From: Simon Davis
Sent: 26 August 2025 15:16
To: Planning.Responses
Subject: FW: LU/141/25/PL 57 River Road Littlehampton SUB PLAN REQUEST
Attachments: 250826 RCTS_River Road A_100 PROPOSED GROUND FLOOR PLAN.pdf

Subject: Re: LUY/141/25/PL 57 River Road Littlehampton

SWEPT PATH ANALYSIS
- CAR PARK 1

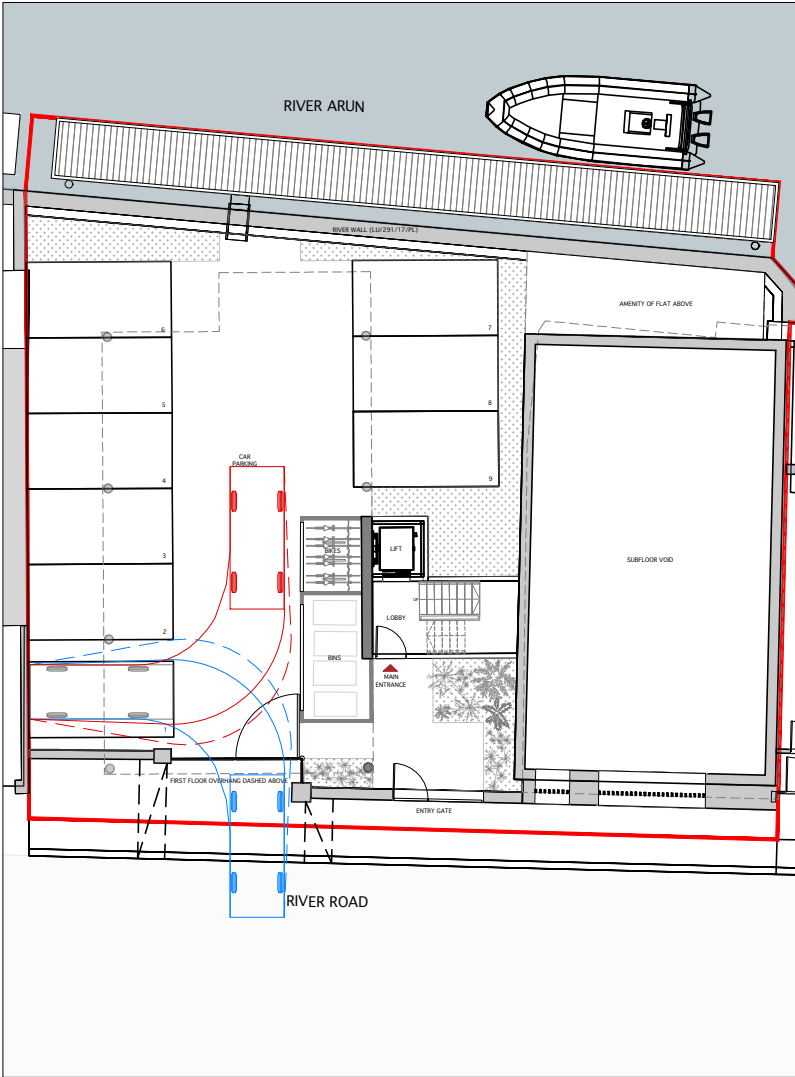
I write to ask whether you can arrange for some tracking drawings to demonstrate how cars will enter and exit parking space 1 (by the entrance) in a forward gear.

I am currently your case officer although I anticipate this being passed to another officer in the next few weeks. Anyway, I write to ask whether you can arrange for some tracking drawings to demonstrate how cars will enter and exit parking space 1 (by the entrance) in a forward gear.

RESPONSE: Please see the attached revised drawing A_100, which includes tracking for Parking Space 1 as requested. The swept-path analysis illustrates a standard vehicle (refer to the notes column for details) entering and exiting Parking Space 1 in forward motion. We trust that these diagrams will satisfy the requirement.
